From: Andrew Wood
Sent: 12 November 2018 16:14
To: Planning.Responses
Subject: FW: FG/140/18/DOC - Landscaping Plan

FG/140/18/DOC - Landscaping Plan

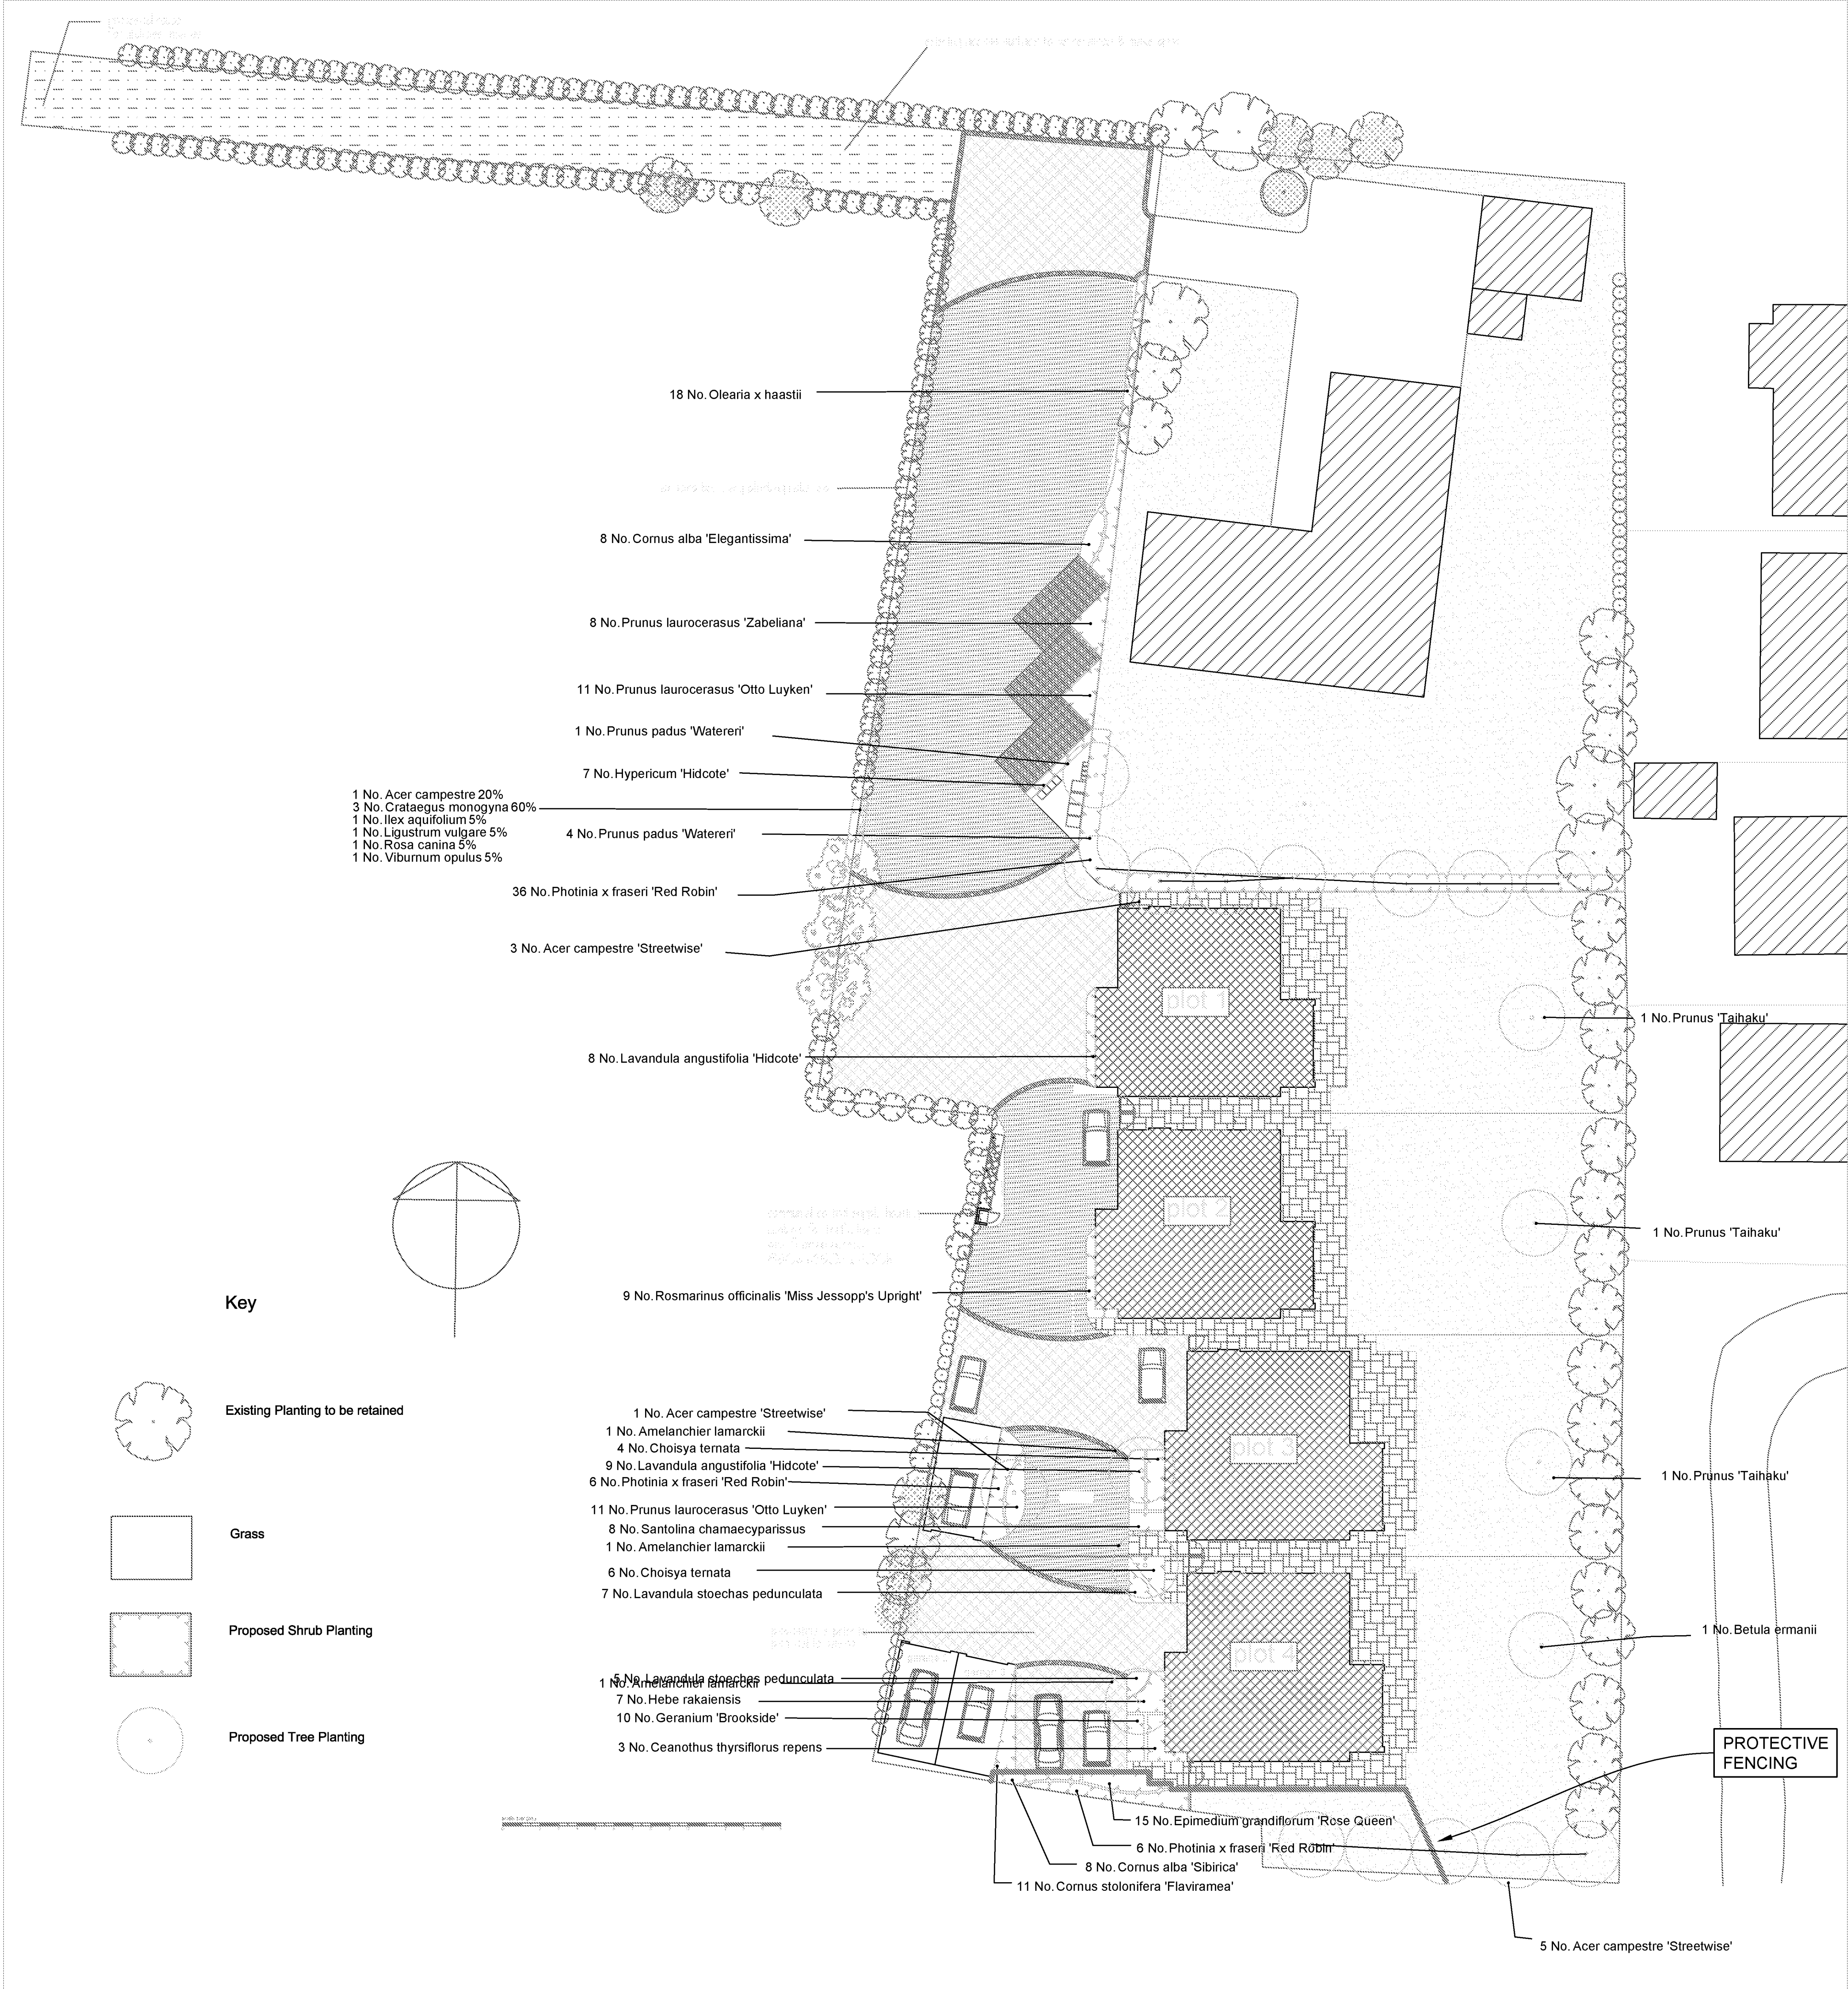
However, the plan on the portal **does not show** the 5 or so Leylandi planted just within 44 along the part of its western boundary privet hedge between myself at 42. All five trees are directly the otherside of my eastern boundary at 42.

Perhaps you could advise me of the applicants intention in relation to the height these LEYLANDI will be allowed to legally achieve, bearing in mind the proximity of their planting i.e. directly at the foot of the existing privet hedge that divides our two plots.

If you have a further planting plan illustrating them as existing planting then please forward such or post on the portal please.

As stated in my email of Friday November 9th the Leylandii along that boundary are considered to be indicated under the term 'existing boundary planting maintained'.

The applicants have provided a further email undertaking to maintain the Leylandii at the height of the regular hedging plants at 2 metres in height.

1) & 2) Noted – The hedging and trees shown are clearly outside the red line of the site boundary and have been assessed as such.

- 2) Noted - The 3 trees shown as existing on the western side of Mr. Salvidges plot as you rightly state are not part of the new build development and have not been considered as part of the approved landscaping plan.
- 3) The Leylandii have been indicated on the plan as 'retention of the existing planting'.
